WELWYN HATFIELD COUNCIL – DEVELOPMENT CONTROL
DELEGATED REPORT

APPLICATION No:	S6/2010/2189/LB
------------------------	------------------------

DESCRIPTION OF PROPOSAL:

The proposal is to rebuild one of the existing staircases by re-using the existing remaining original treads and runners and replacing the metal structure with a new oak framework.

H1993 – 32 Fore Street

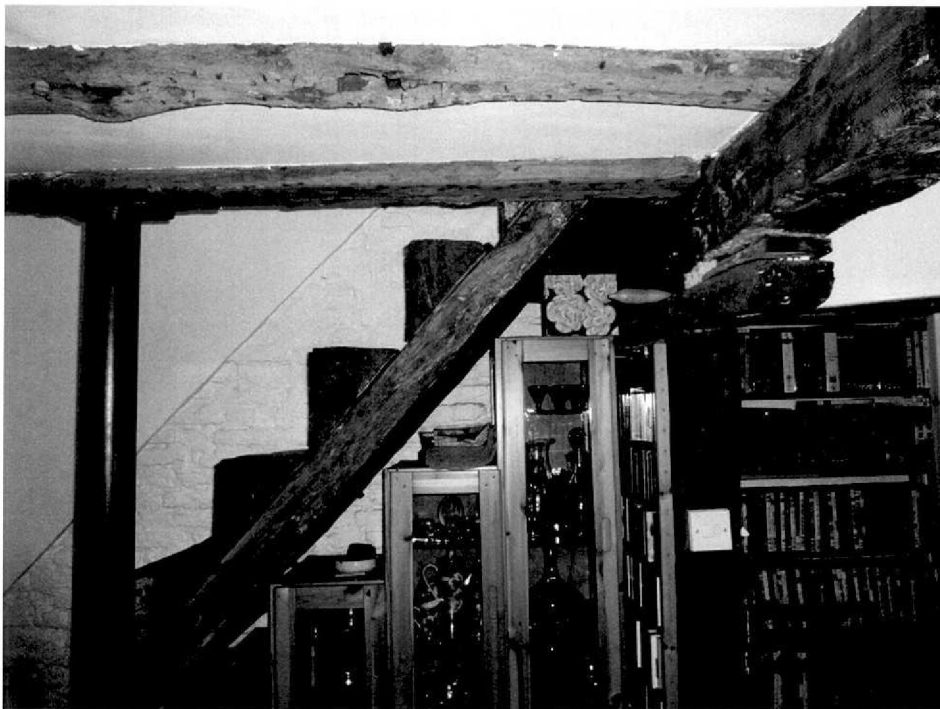
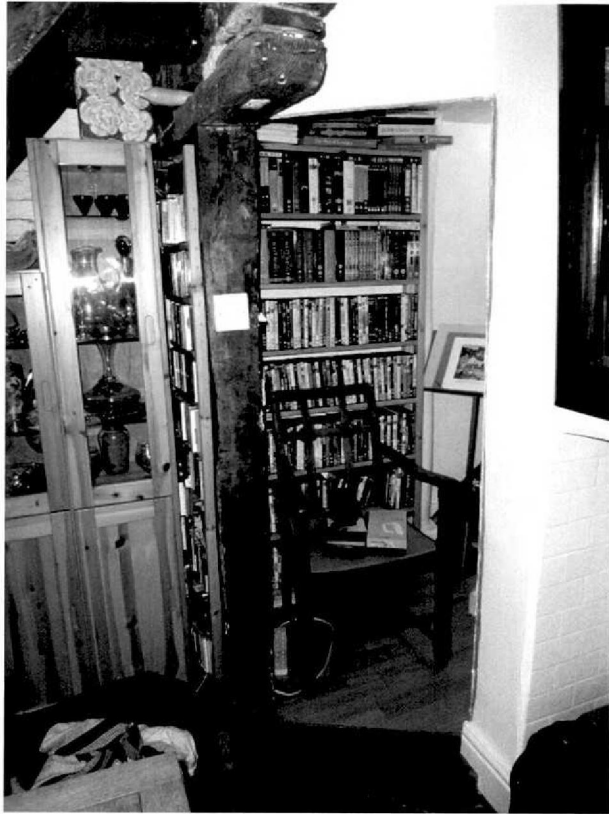
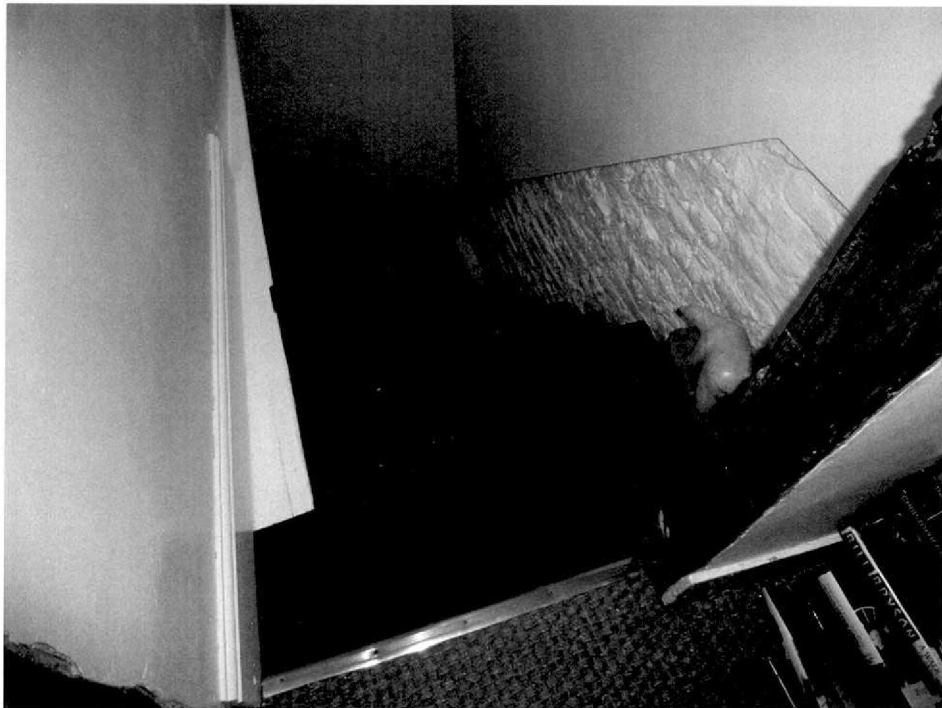
The current staircase appears to have been significantly altered with a metal frame used to support the remaining 6 oak treads in the top section.

The current design is unsympathetic with the overall historic character of the dwelling and according to the applicant is impractical and unsafe.

EXISTING & PROPOSED PLANS & SECTIONS

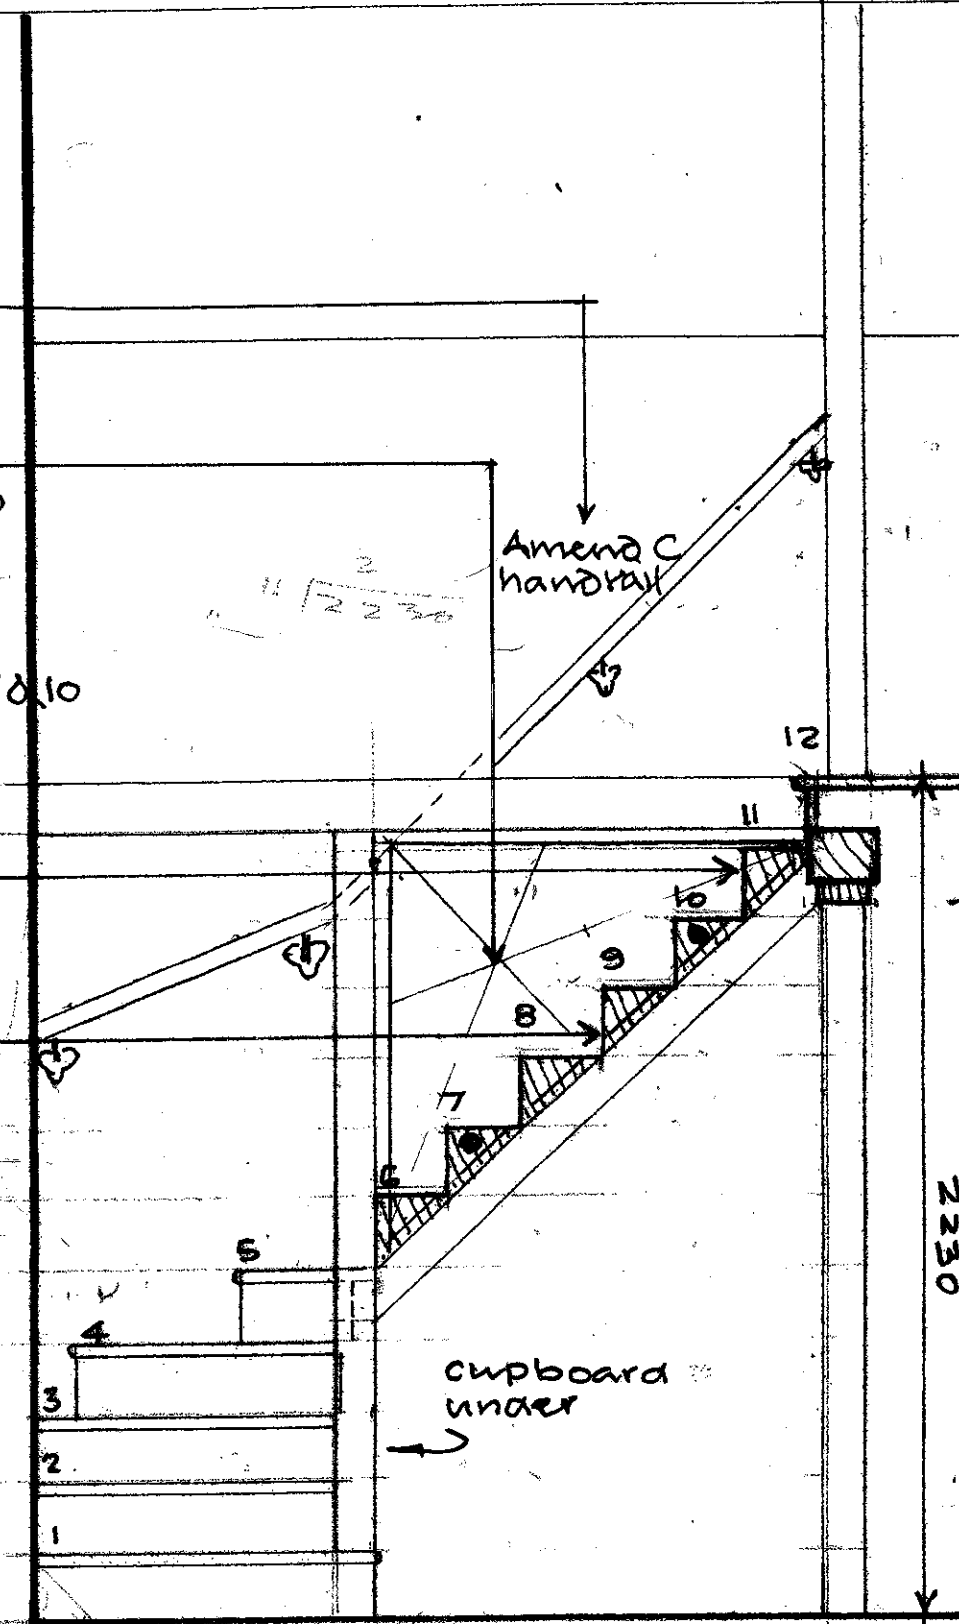
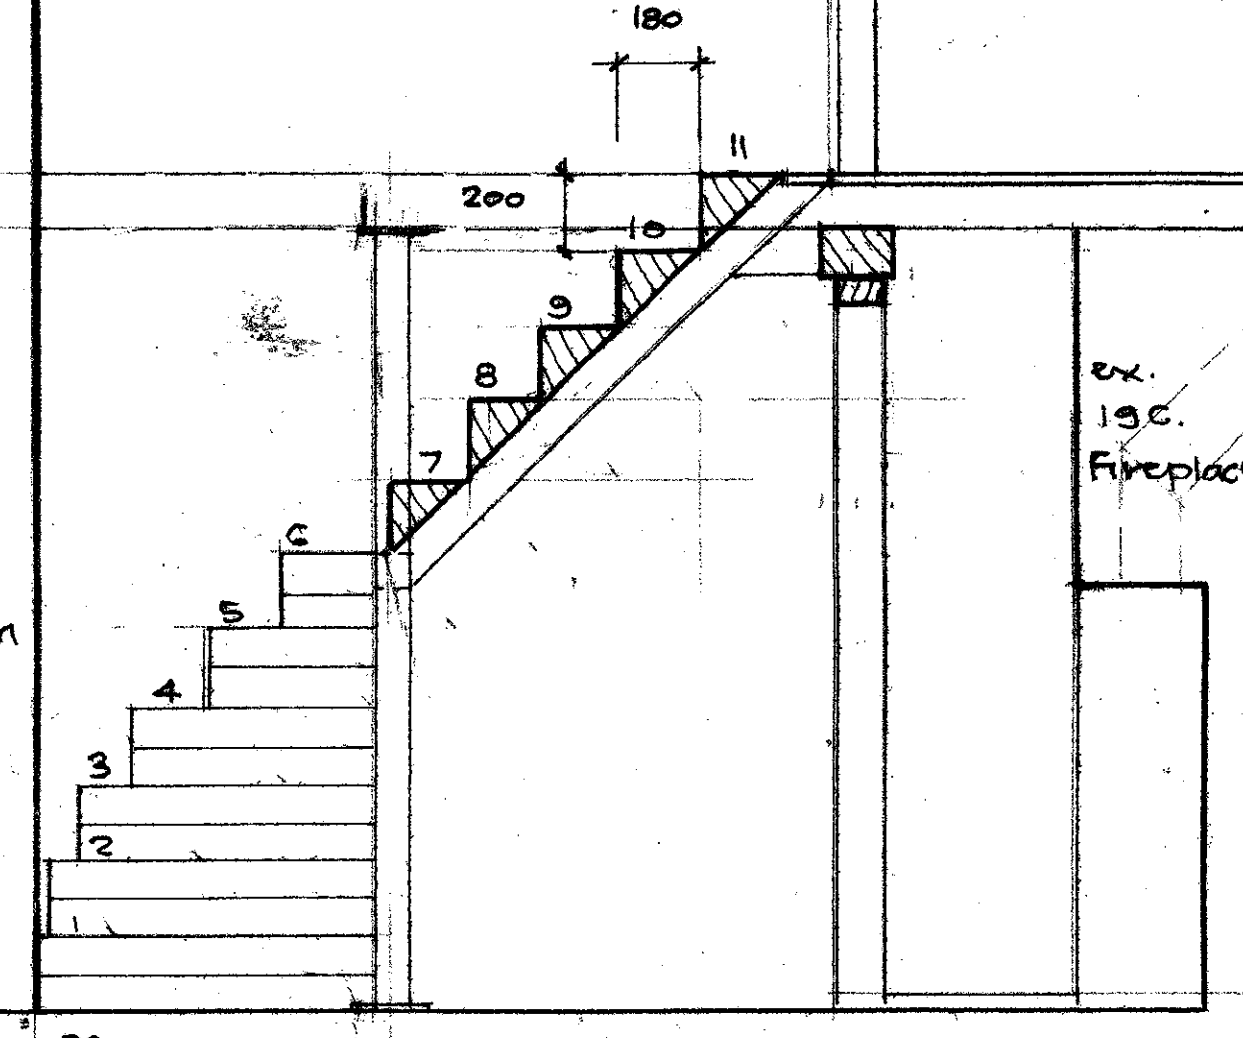
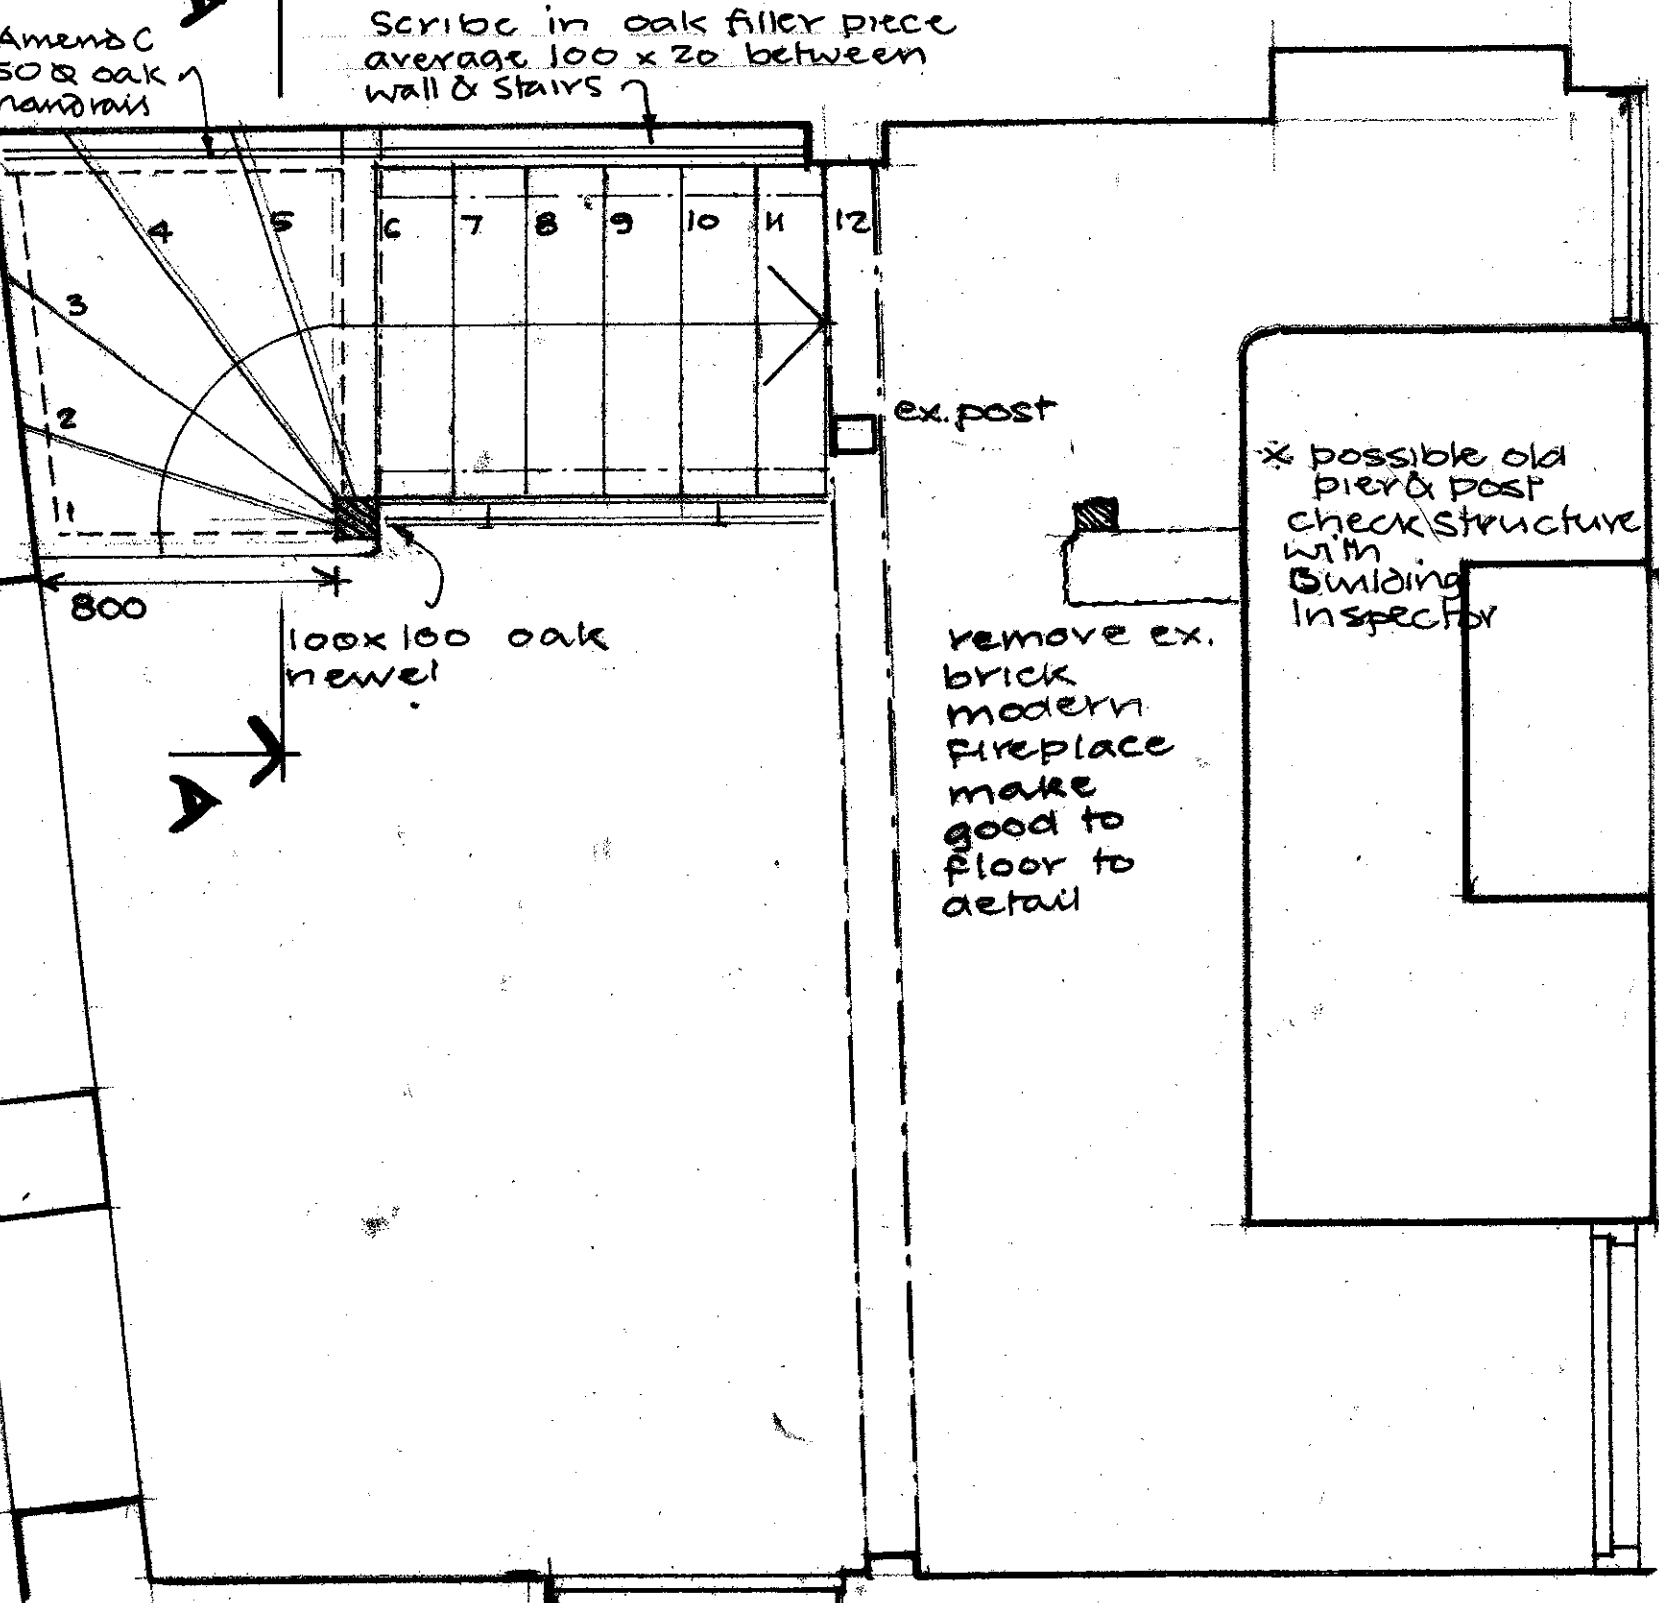
At the site visit, it was possible to ascertain the condition of the 6 remaining solid oak steps and the proposal to use the existing vertical face of these (which is in better condition) is a logical approach. The first set of design drawings showed another section of timber being fixed to the top surface of these original steps, but these were thought to detract from the appearance of these and so best avoided.

It was agreed on site that the view of the Building Control Officer would be needed to finalise the finished structure (and surface of the steps), but for the time being, the proposal would be to retain the existing steps in their original condition.

In regards to the fireplace, this has been added to at some point, possibly in the last century. The removal of this to expose the original fireplace is not considered to be an issue. At the site visit it was noted that the left hand side appeared older, and probably formed part of the original wall. The drawings have therefore been amended to show that this element is to be retained.
